320190763P

Feazer Cottage

Re: Documentation to support application for variation/removal of conditions relating to application number 3/2019/0217

Conditions to be varied or removed:

SJ Bialecki Limited Building Surveyors
Drawing no 6004-a
Scale 1:50
Plot A Floor Layouts
Proposed Residential Development On Land At Ribblesdale View Chatburn

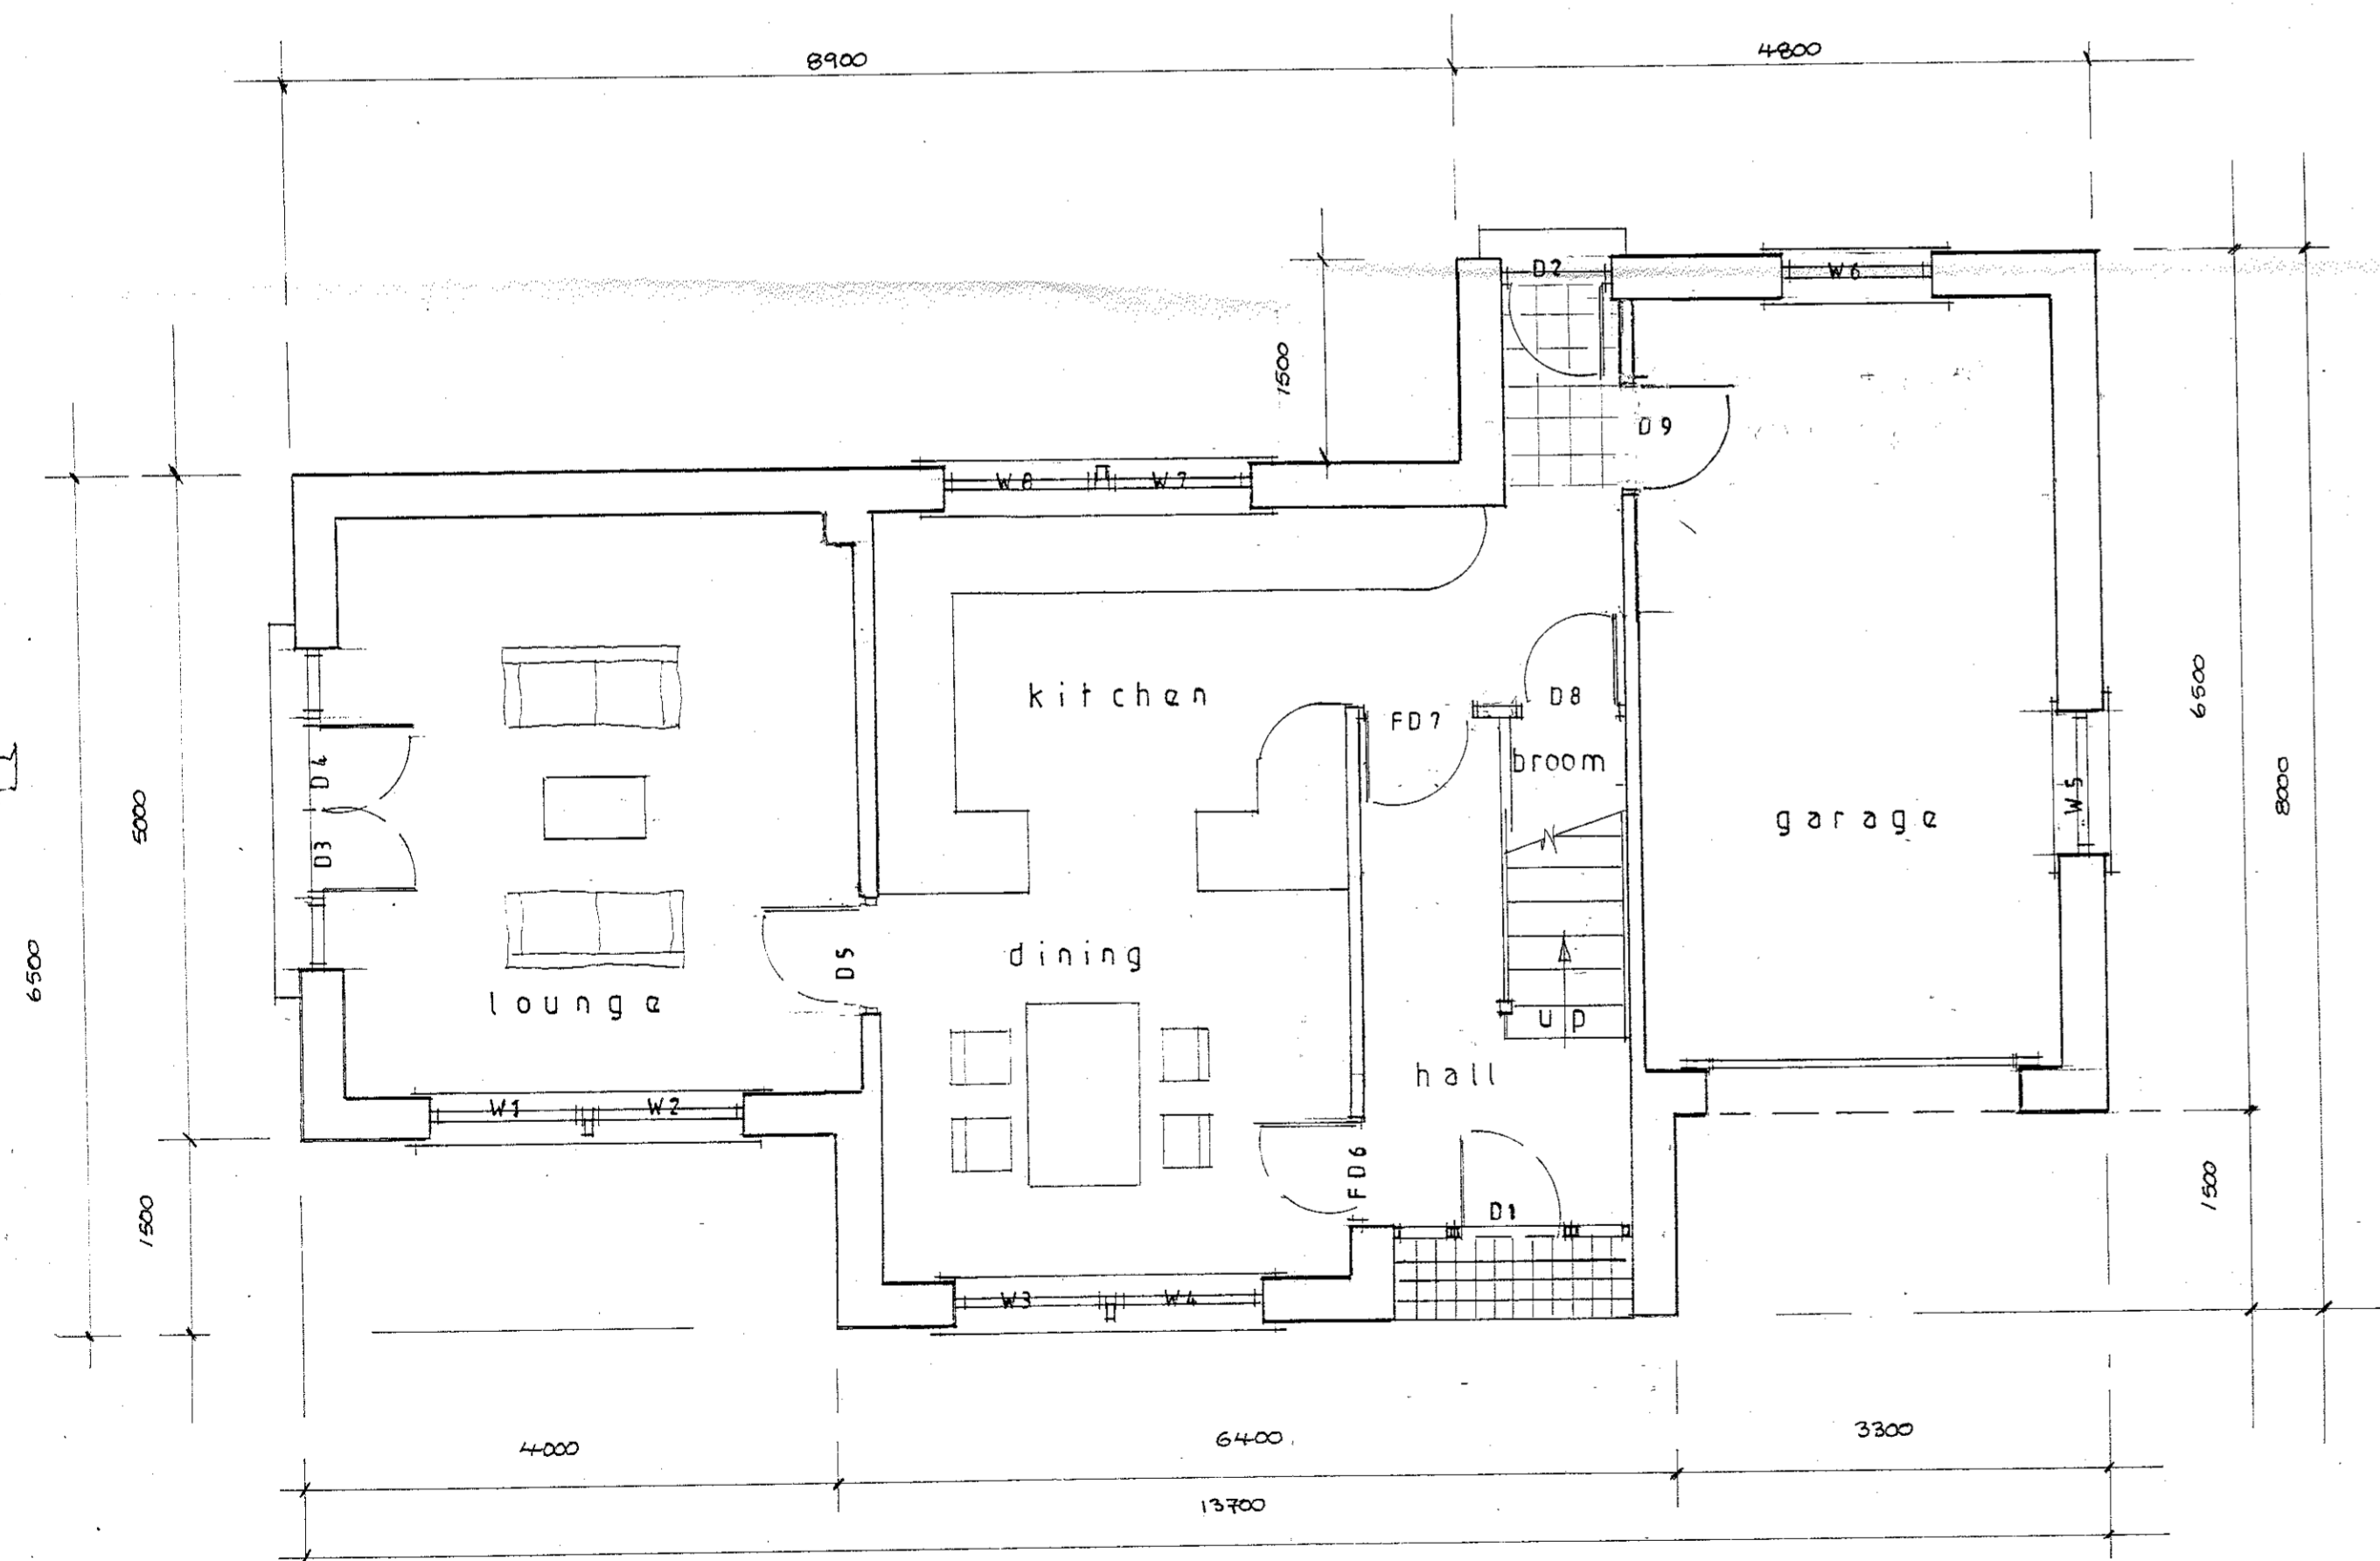
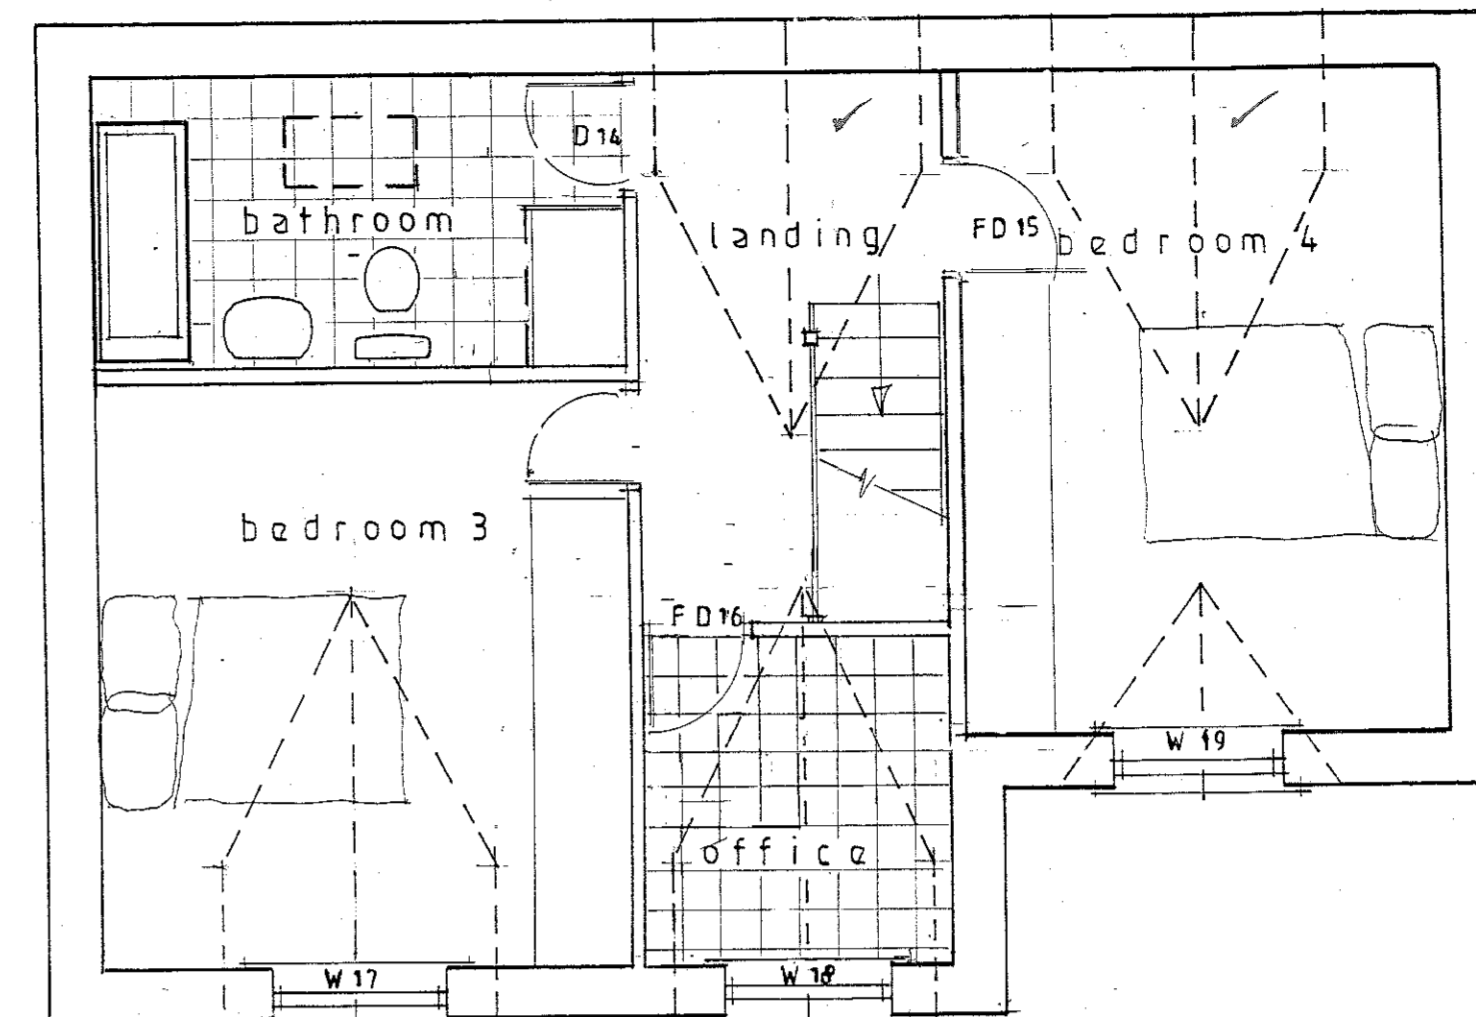
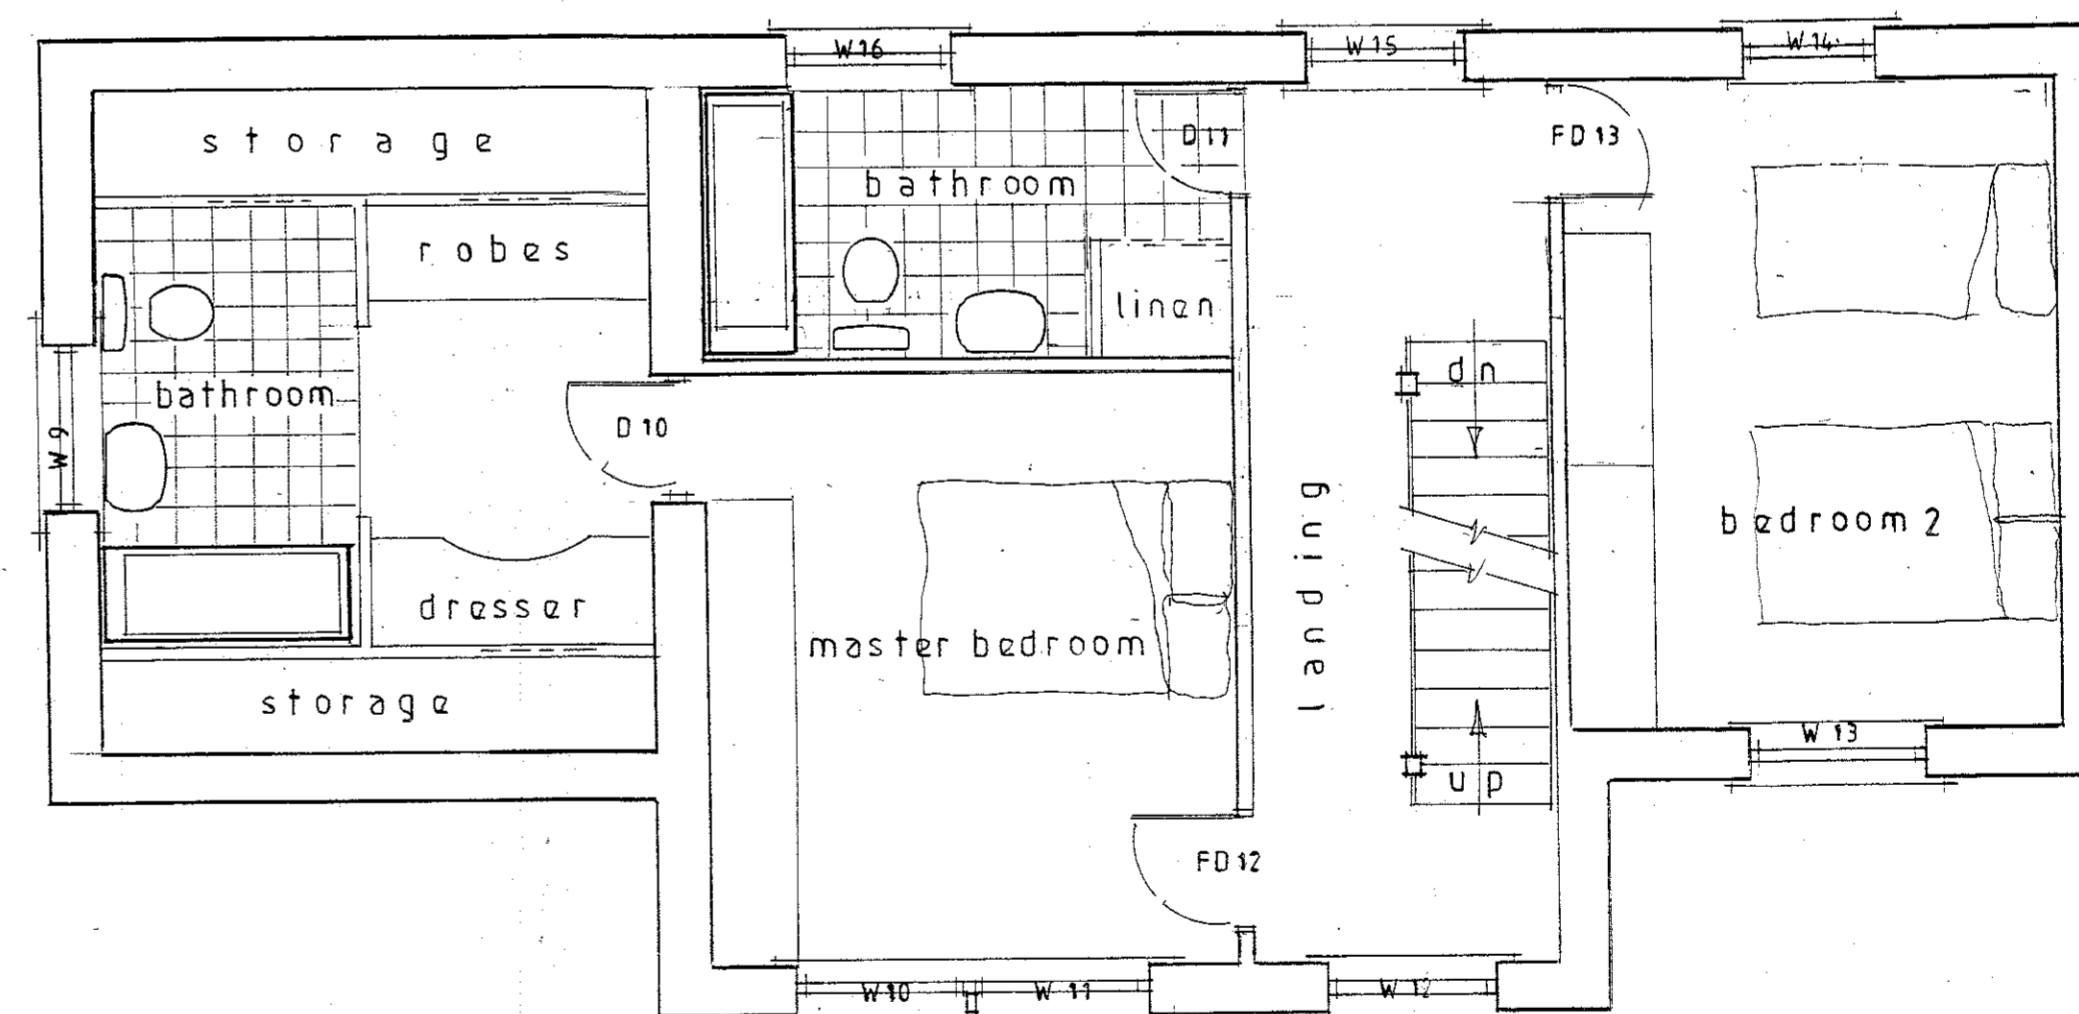
We would like to submit an application to vary this condition due to a redesign and reduction in property size by approximately 20% for Plot A, previous application which has now been withdrawn 03/2019/0476.

6004 Plot A Floor Layout (Redesign of Plot)

6004a New Plot A Floor Layout
